## PLAN REVIEW SHEET

| <b>Petition:</b>         | 2008-091  | <b>Fax:</b>           | 704-432-1277   |
| <b>Location:</b>         | Approx. 7.13 acres on E side of<br>Statesville Rd betwn W. WT Harris Blvd.<br>And Metromont Pkwy. | <b>Email:</b>         | <a href="mailto:dmcDonald@ci.charlotte.nc.us">dmcDonald@ci.charlotte.nc.us</a> |

TECHNICAL DATA SHEET

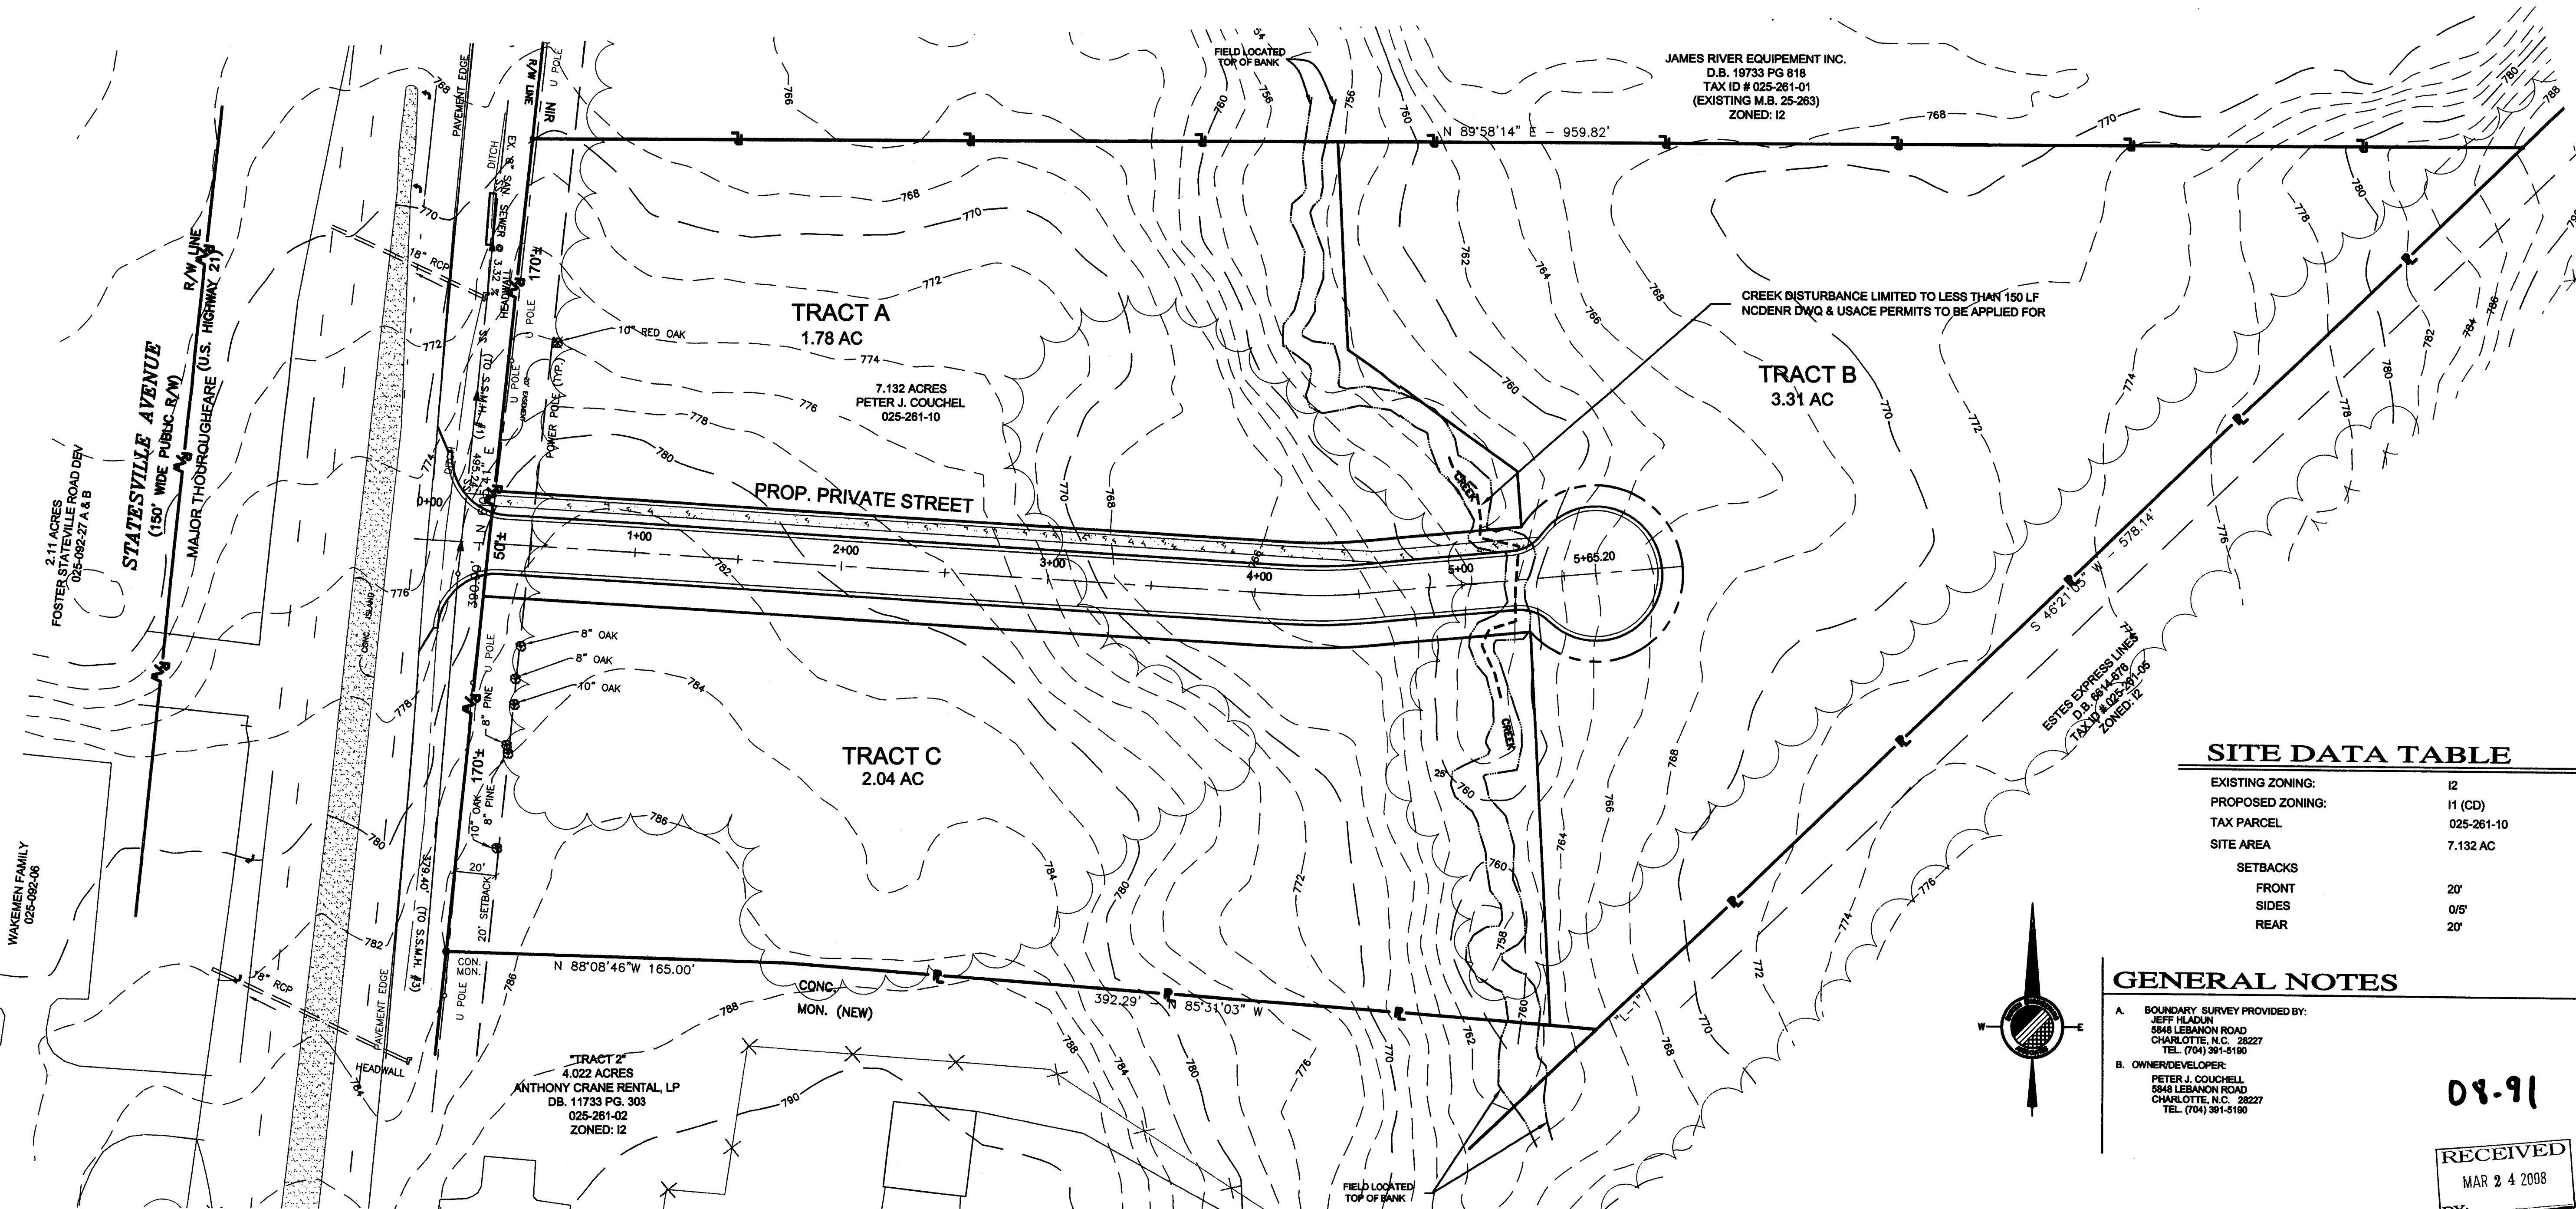
- 1) **The petitioner's site is currently served by CATS Route 53x: Northlake Express.**
- 2) **CATS requests a waiting pad to be constructed on Statesville Road. The waiting pad should be constructed to CATS Development Standards 60.01 A (see attached).**

A waiting pad is the connecting piece of concrete which is installed from the back of curb through the planting strip to the sidewalk (see attached). The waiting pad provides an ADA accessible bus stop boarding/alighting location for CATS' passengers.

Please designate such in the site plan and/or accompanying notes. Please contact Leonard Ganther (CATS Operations) @ 704.432.1283 prior to demolition or construction, to coordinate the final location of the waiting pad.
